Our Ref: 23/03357/CL2PD

**South Cambridgeshire District Council
Application for Certificate of Lawful Use or Development**

Proposal: Certificate of lawfulness for the erection of a single storey rear extension.

Site address: 53 The Oaks Milton Cambridgeshire CB24 6ZG

Location Plan

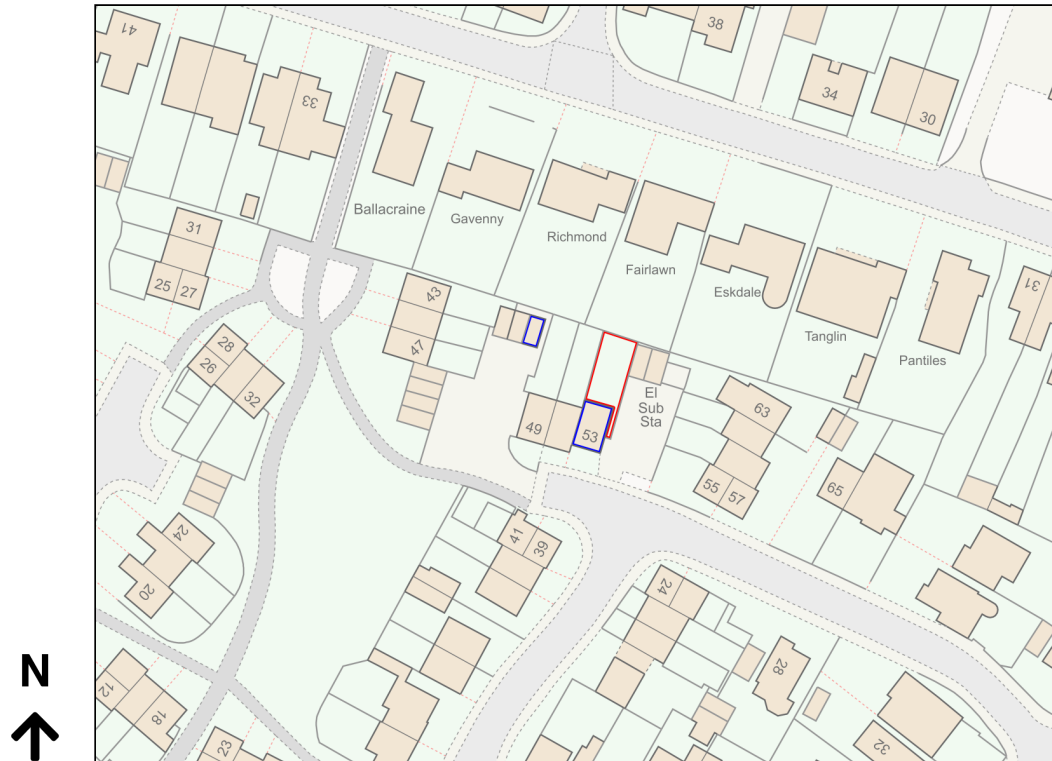
0. The location plan submitted has shown the property known as number 51 within the red outline. Please provide an amended location plan which has the correct property outlined in red. As it stands the property No. 53 is shown outlined in blue.
